**ADC Planning Consultation
Response from the Conservation Officer**

Application Number	AW/25/15/A
Address	The Ship Inn Aldwick Street Aldwick PO21 3AP
Description	3 No. externally illuminated fascia signs, 2 No. non illuminated fascia signs & 2 No. non illuminated panel signs to various elevations (resubmission following AW/215/14/A).
Case Officer	Mr. S, Davis

FRONT ELEVATION

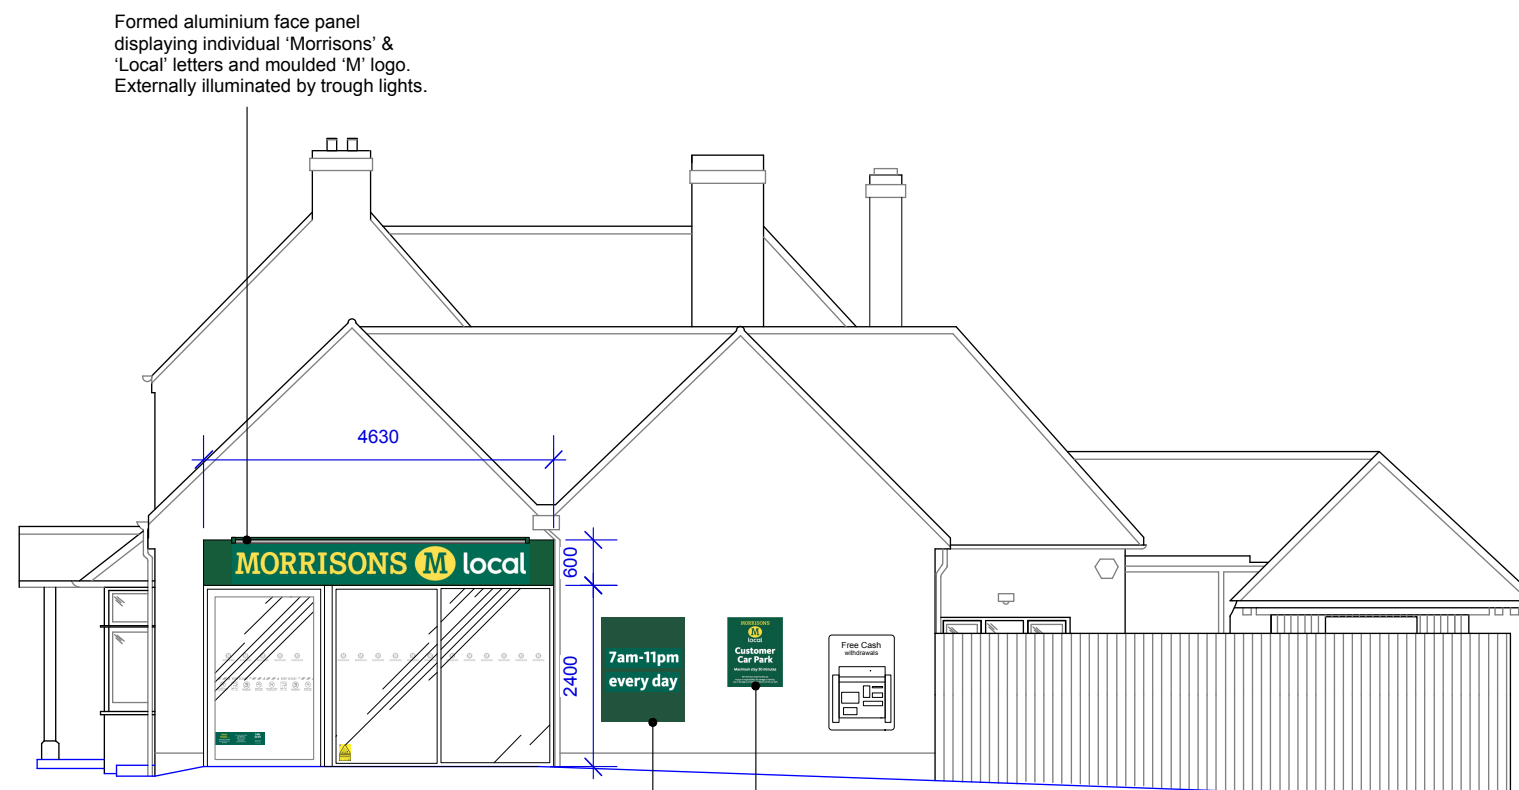
Front elevation: the sign seems located so that it accommodates the space between the two openings. It is suggested that the sign is redesigned to include only the 'M local' element. This revised text could be slightly larger, but not such that it accommodates the entire section between the two windows. An alternative could be to retain reference to the old ship, and have a hand painted sign stating something like "M Local at the Old Ship".

Side elevation (main entrance): is there a need for so many signs on this elevation? The number, size and location are visually cluttering. Could the hours of opening be placed on the third glazing panel of the opening, and the car park sign located closer to the cash point?
